PLANNING AMENDMENT

Application No. H09/0679/00/A1
Date Registered 19 DEC 2001
Case Officer LS

Amendment: Alterations to entrance stairway to first floor flats
Dwg.No. SD00-024/2 received 19 December 2001

RE: PROPOSED CHANGE OF USE AND CONVERSION OF COMMERCIAL PREMISES INTO FLATS AT 2 AND 2A VICTORIA STREET HOLBEACH SPALDING Lincs FOR LEOWARE LTD

SD00-024/2

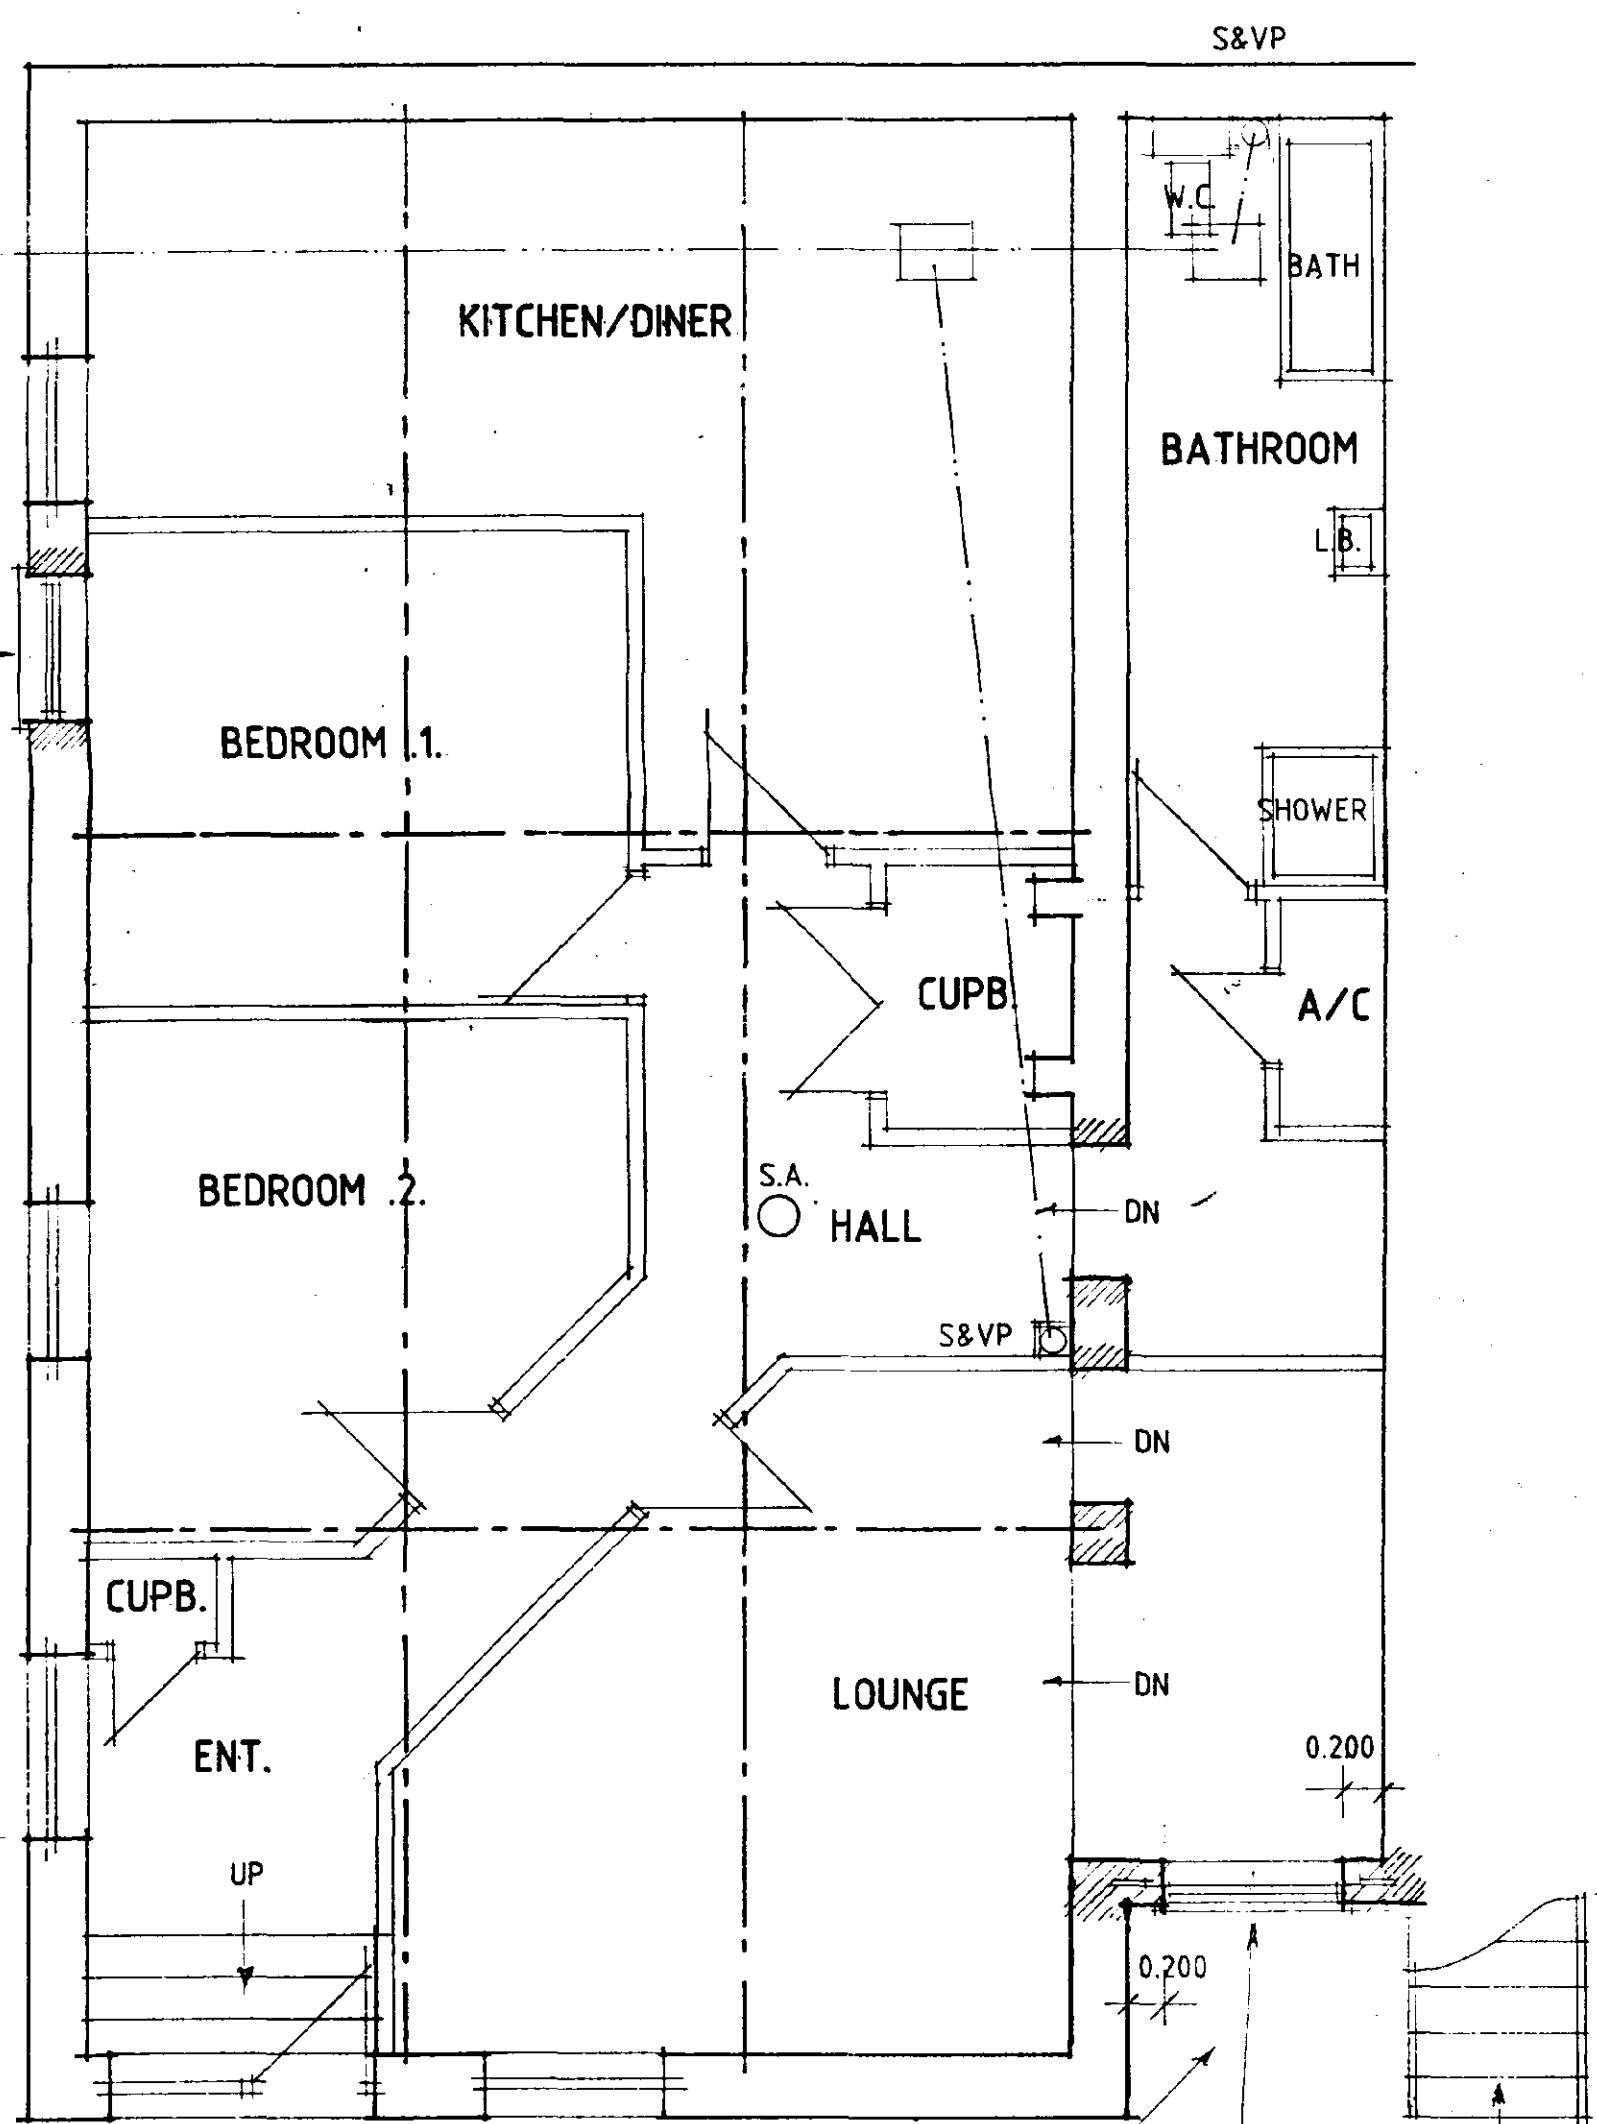
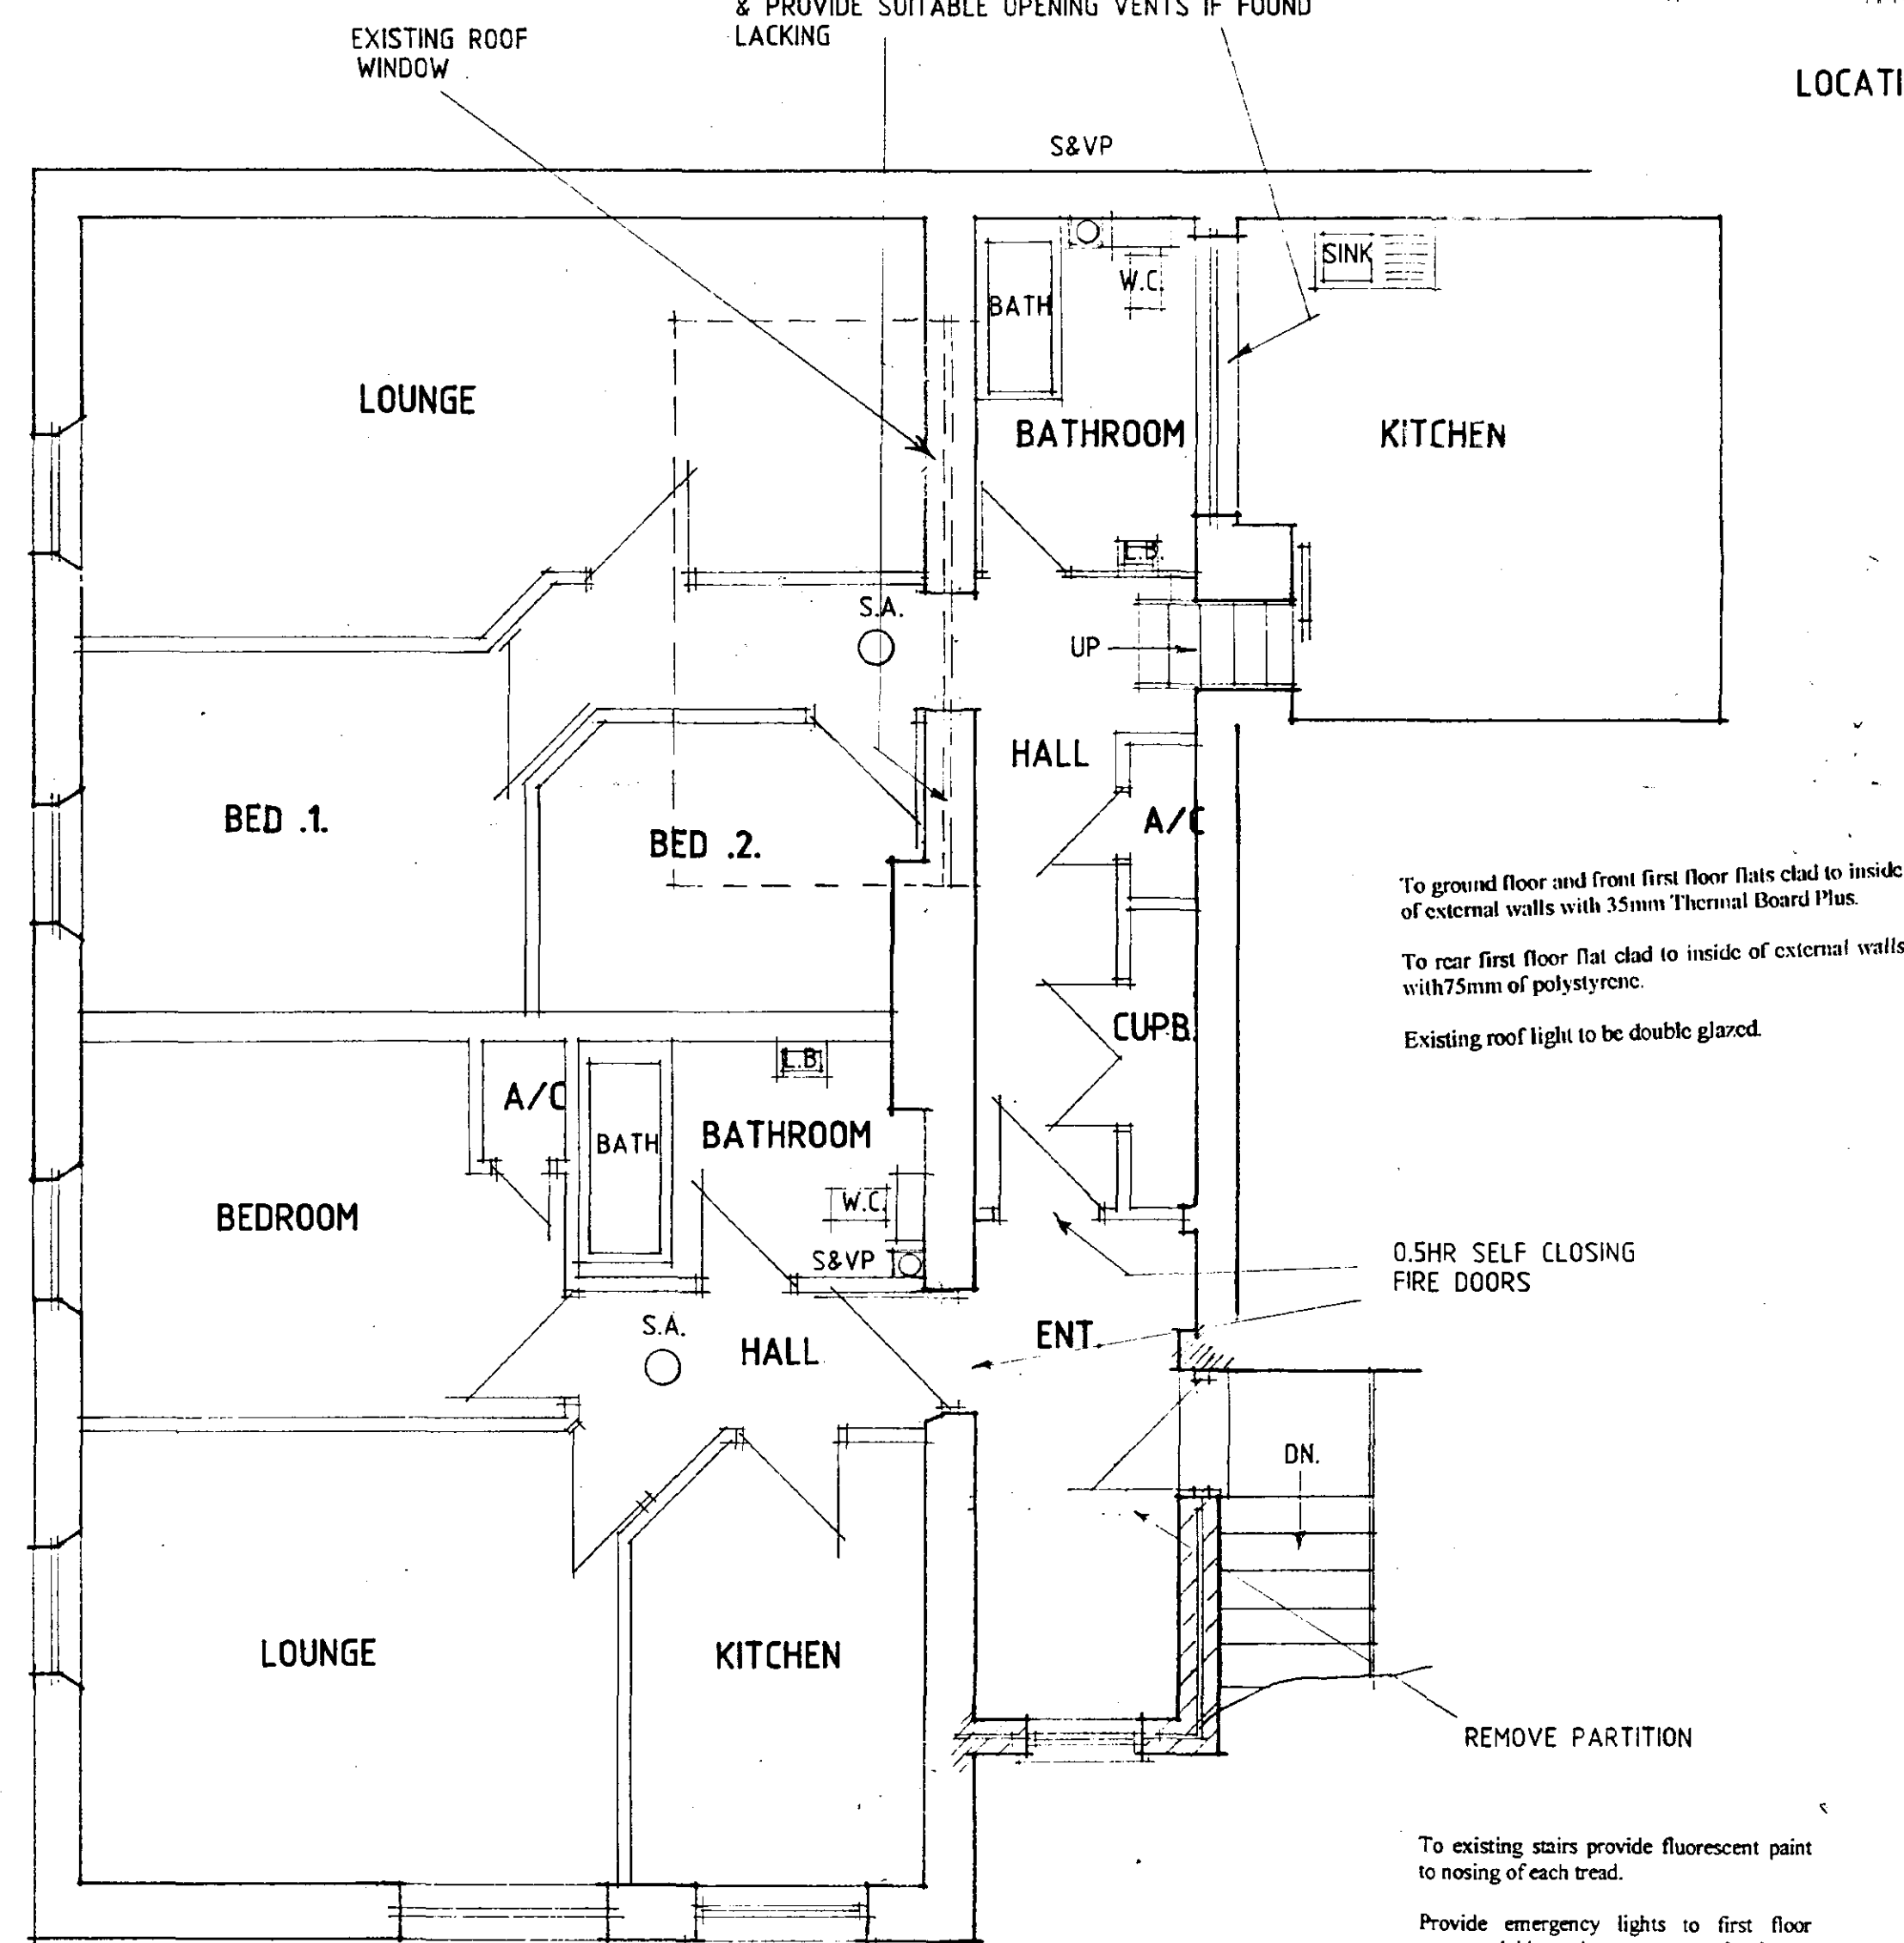
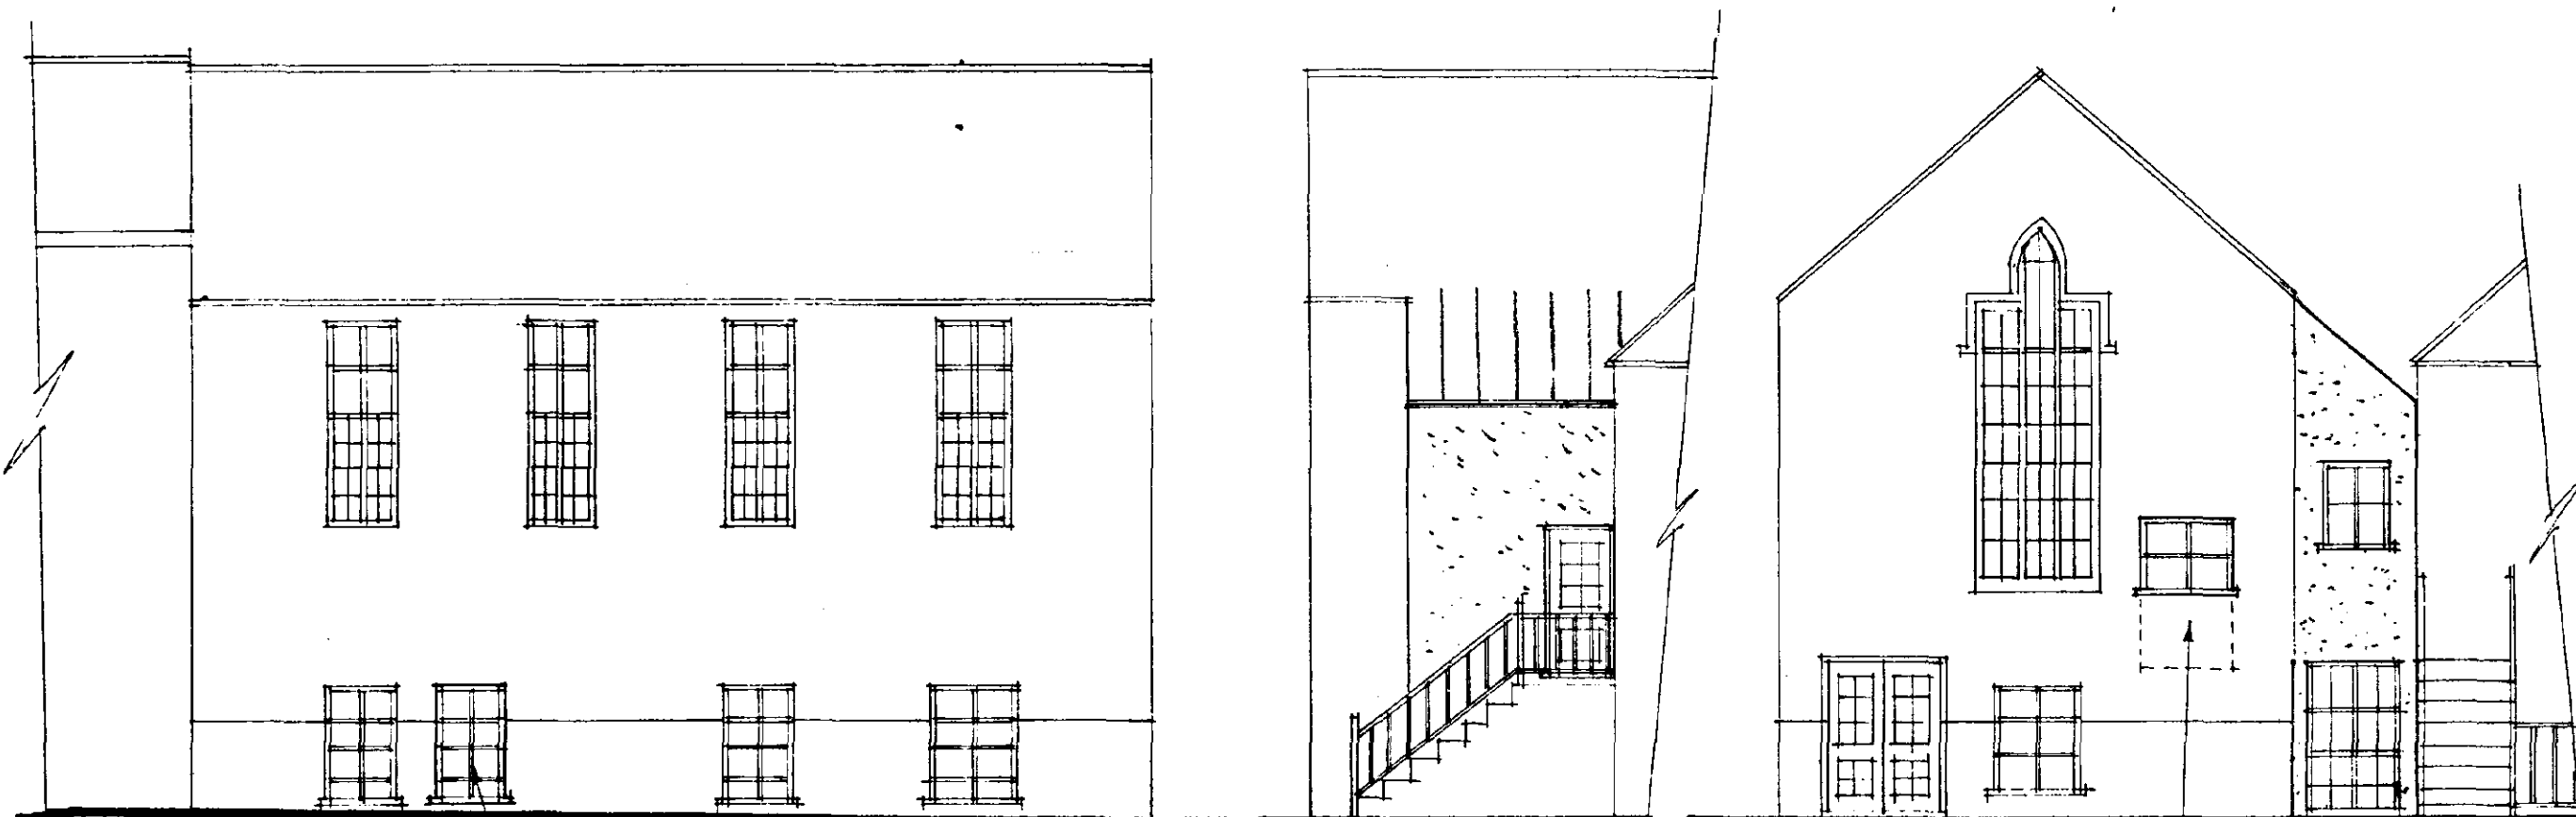
ALTERATIONS TO ENTRANCE
STAIRWAY TO 1ST FLOOR FLATS

Further to our recent meeting on site and subsequent telephone conversations, alterations have been made to the front entrance stairway to the first flats and I therefore enclose the following:

The amended details submitted in respect of the above proposal have now been considered and there are no objections to the amendment being implemented to the extent described above.
